Our Ref: LU/66/20/HH
Your Ref:

Town & Country Planning Act 1990 (as amended)
Town & Country Planning (Development Management Procedure) (England) Order 2015
Application for Planning Permission for Works or Extension to a Dwelling

Development Construction of brick built and flat roofed rear extension
Location 16 Beaumont Park Littlehampton

16, Beaumont Park, Littlehampton, West Sussex, BN17 6PE

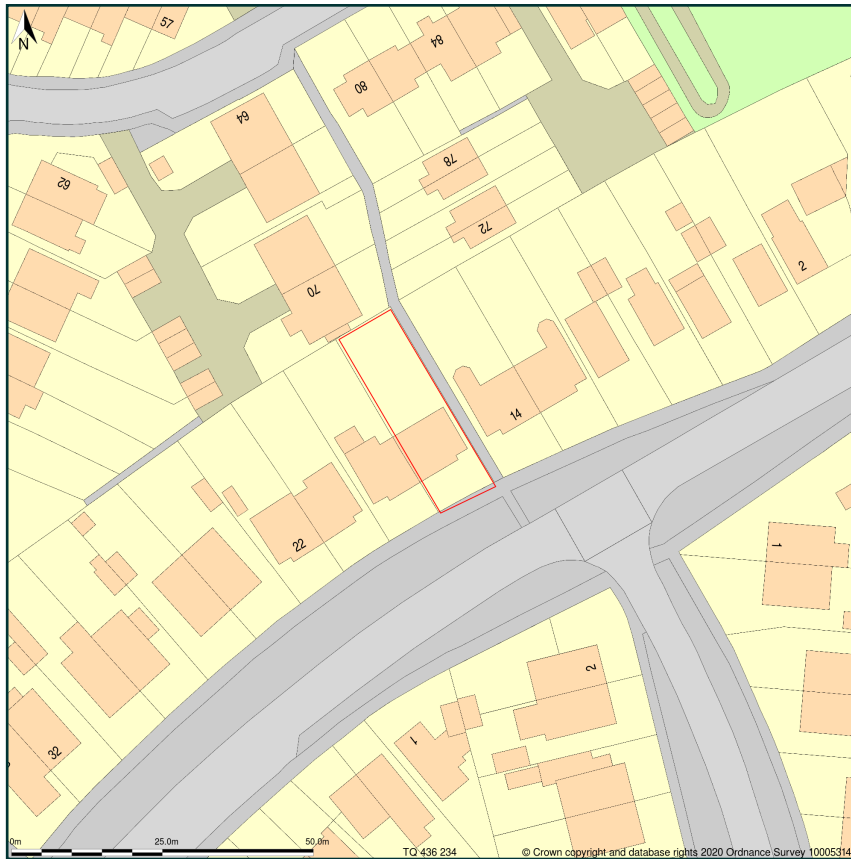
Block Plan: Please submit the block plan as a PDF document and include dimensions from the proposed extension to all site boundaries.

Proposed Bathroom 1:25 Scale

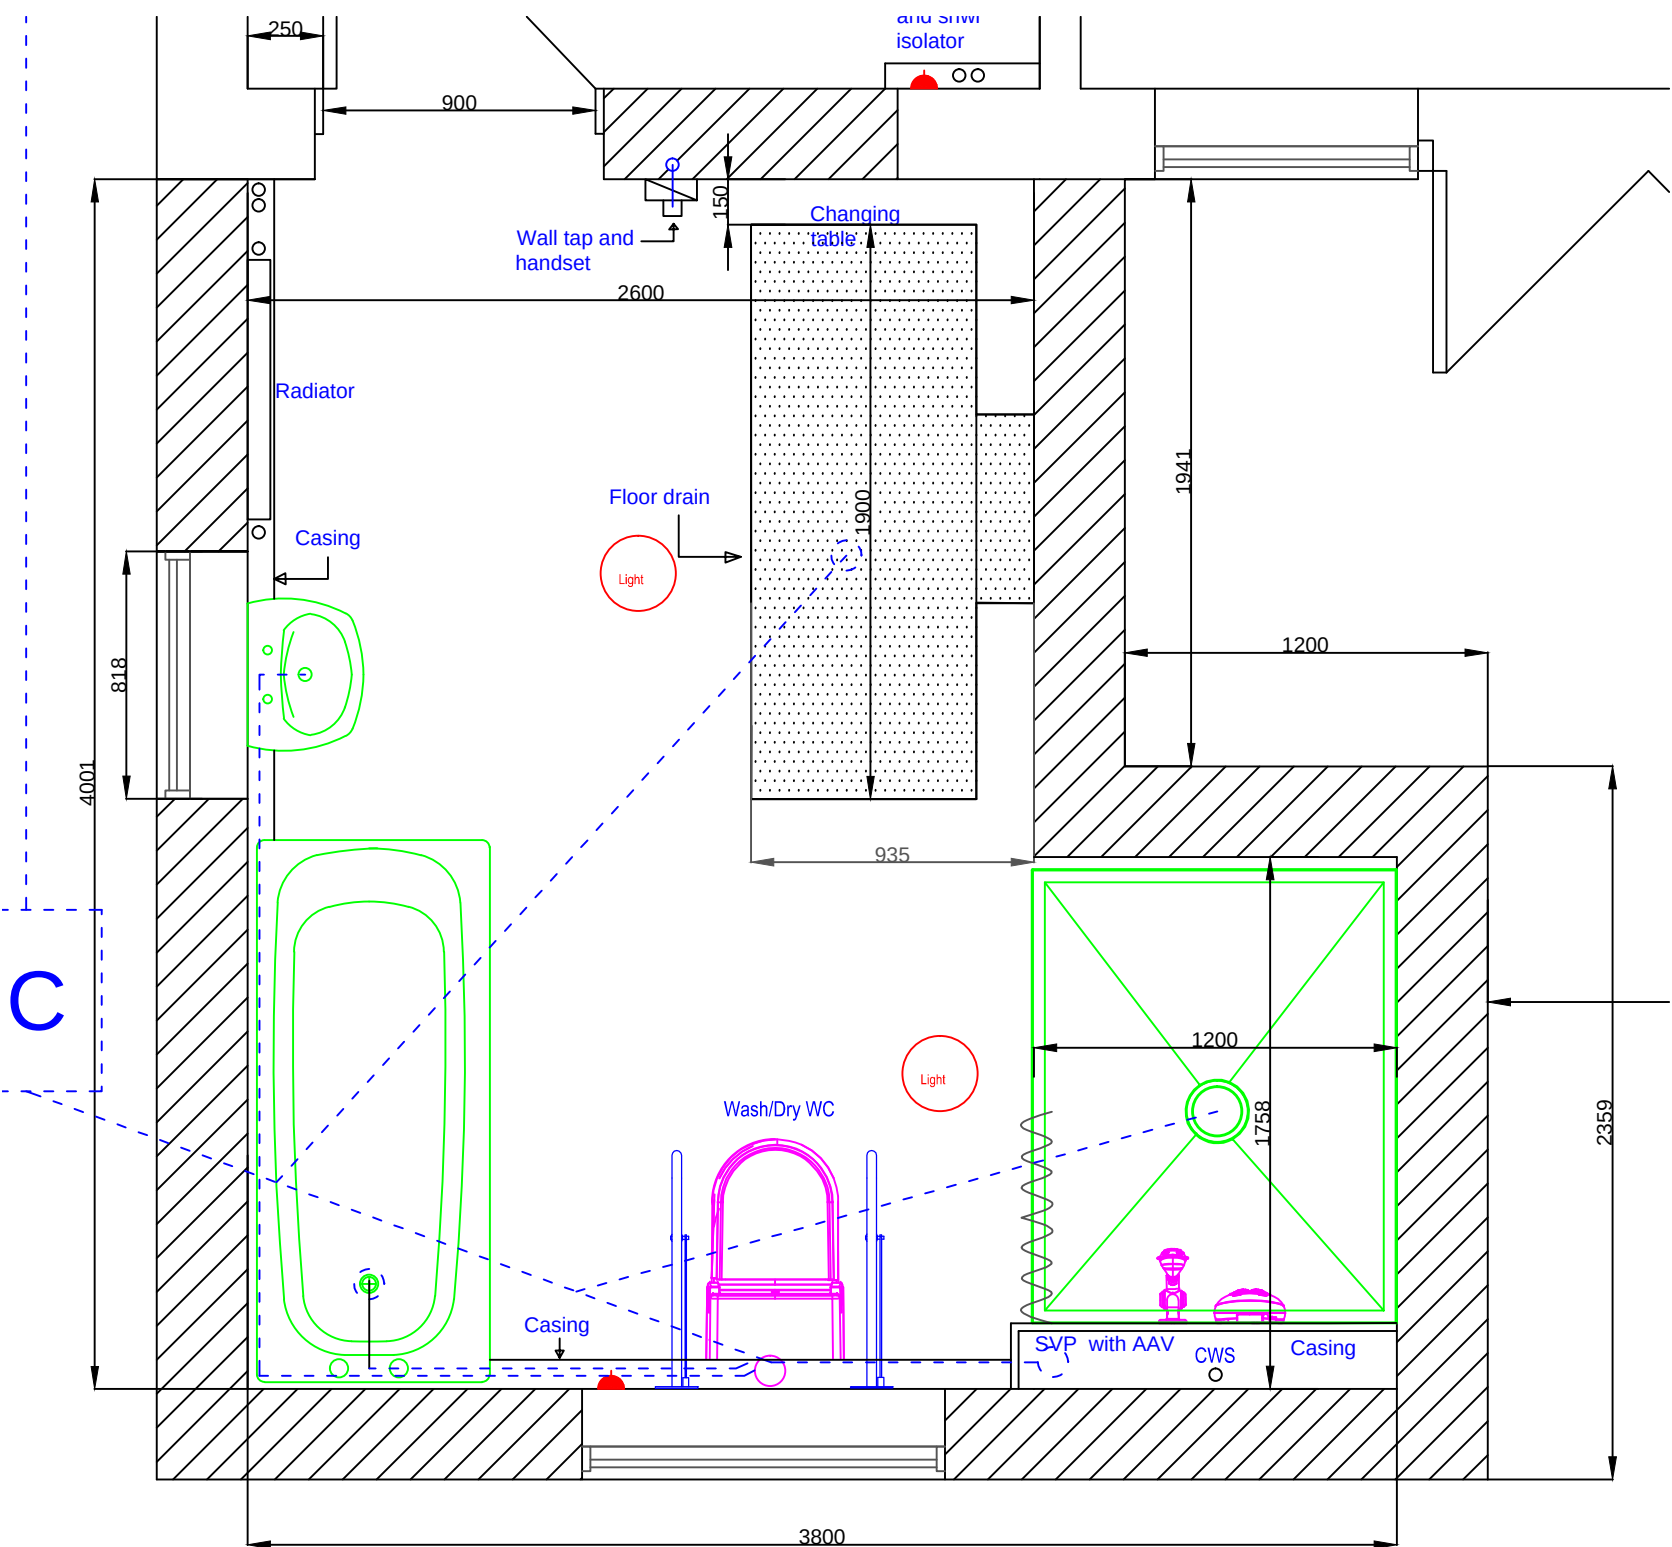
Floor Plan: The floor plan which does not measure to scale needs to measure to scale. It is currently measuring to 1:25 with your permission we can add this scale for you.
